Application Ref:	3/2025/0199			 Ribble Valley Borough Council <hr/> www.ribblevalley.gov.uk
Date Inspected:	01/05/25	Site Notice:	01/05/25	
Officer:	LW			
DELEGATED ITEM FILE REPORT:				APPROVAL

Development Description:	Proposed change of use of temporary holiday let back to annex accommodation, conversion of garage to habitable space and fenestration alterations to existing detached garage/ annex building.
Site Address/Location:	Bridgeway, 16 Brookes Lane, Whalley, BB7 9RG.

SHEET:
PROPOSED ELEVATIONS

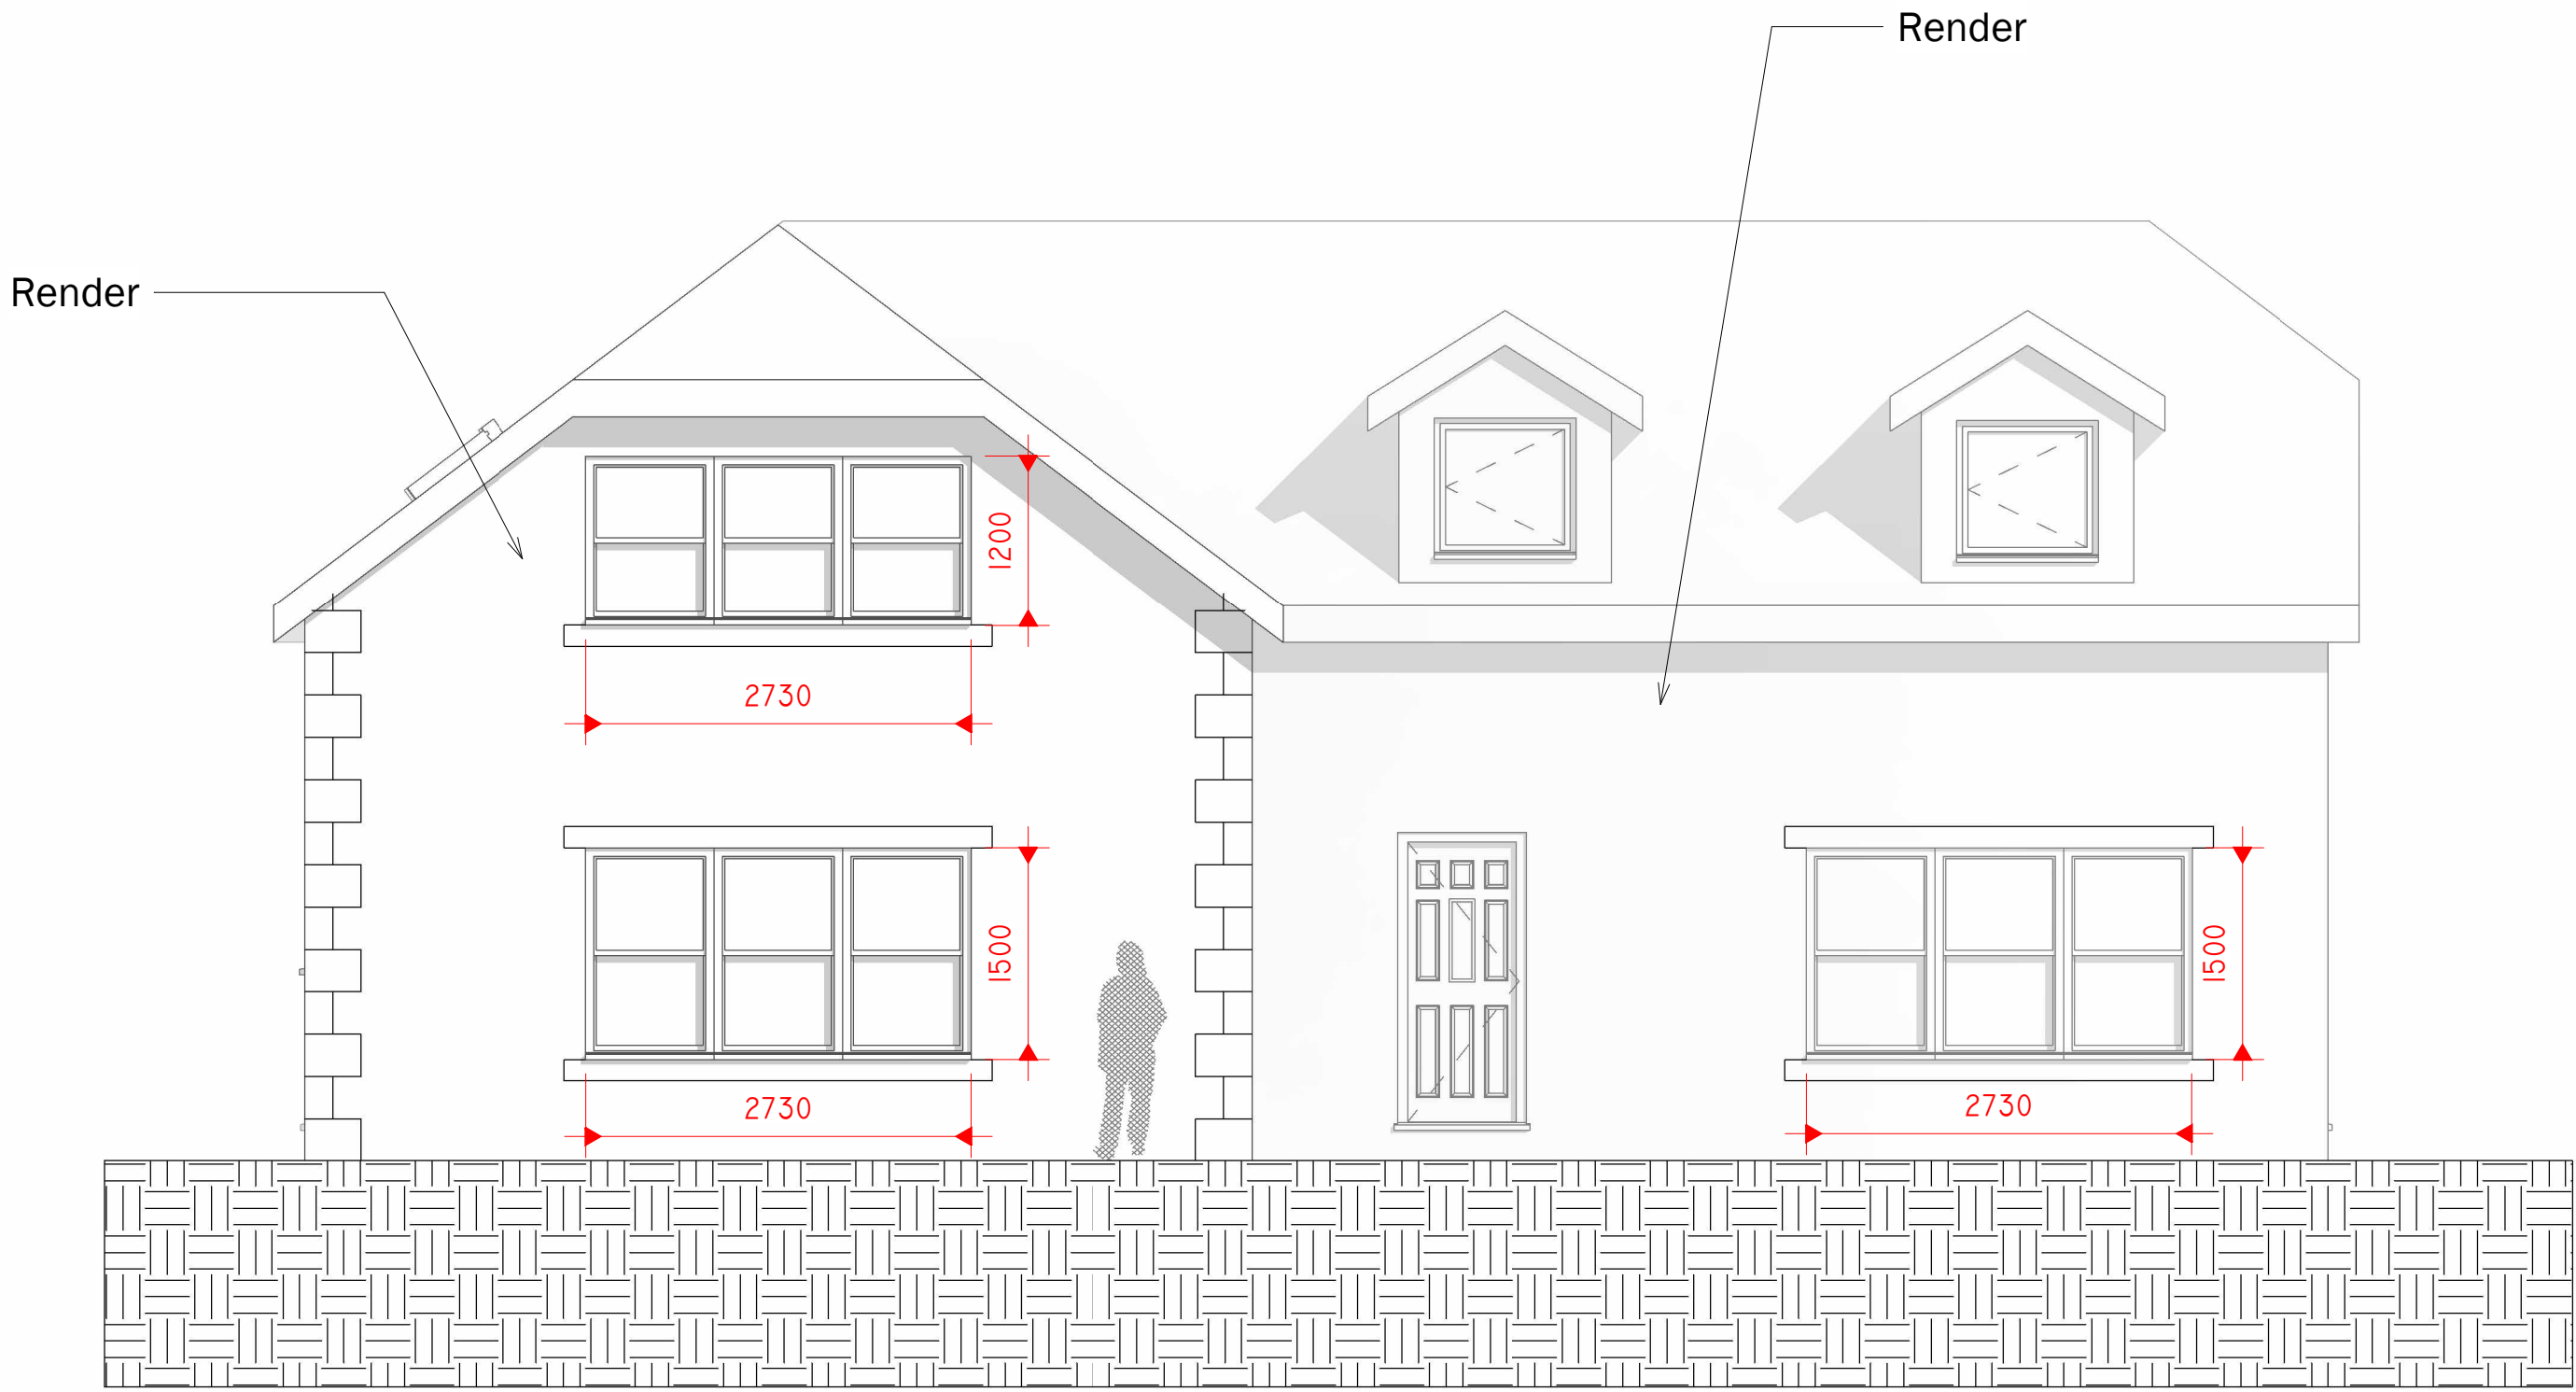
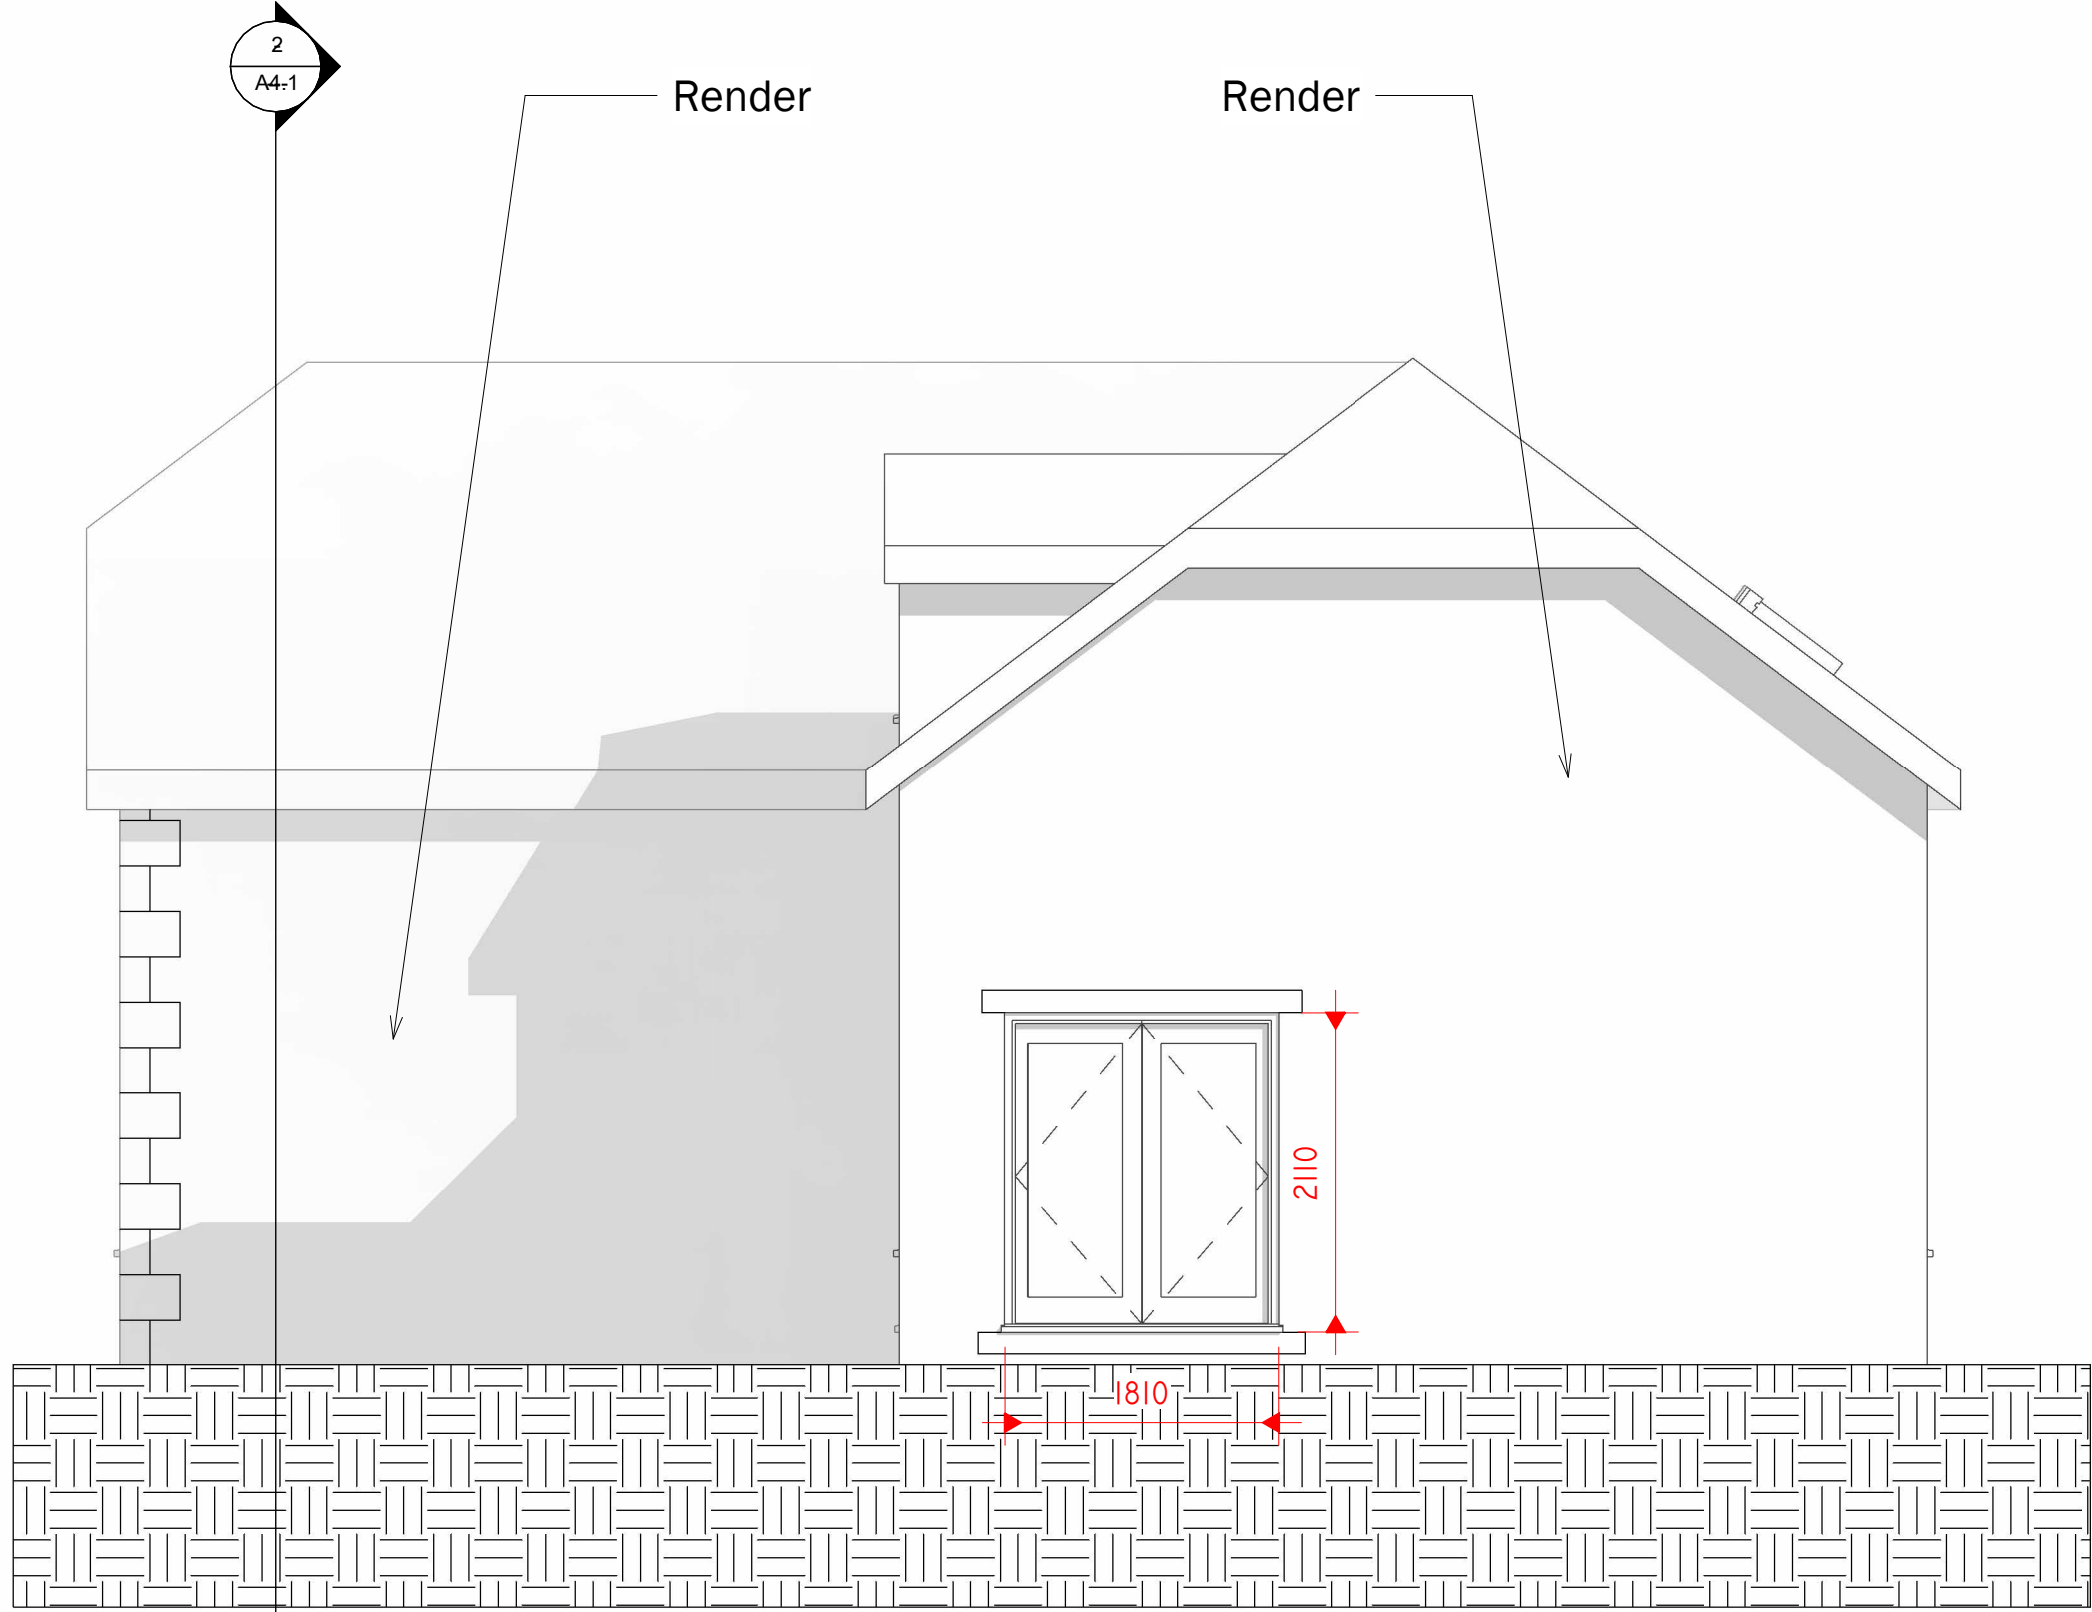
Consent is sought for the change of use of the temporary holiday let back to annex accommodation, conversion of the existing garage into a habitable space and fenestration alterations to the existing garage/ annex building, including the replacement of the existing garage door with 1no. window opening. The proposal has been amended since initial submission following concerns raised by the Officer.

Following discussions with the Agent, the proposed works have been reduced, with the proposed roof alterations, front porch and bay window all removed from the scheme. The number of new openings to

the building has also been reduced. The amended scheme would comprise relatively modest fenestration alterations to the existing built form of the detached outbuilding and therefore it not considered the proposal would result in any significant adverse harm upon the existing visual amenities of the surrounding landscape or the setting of the designated Whalley Conservation Area that would warrant the refusal to grant planning permission in this particular instance. The amendments are therefore considered sufficient to address the aforementioned concerns, with the revised scheme deemed acceptable.
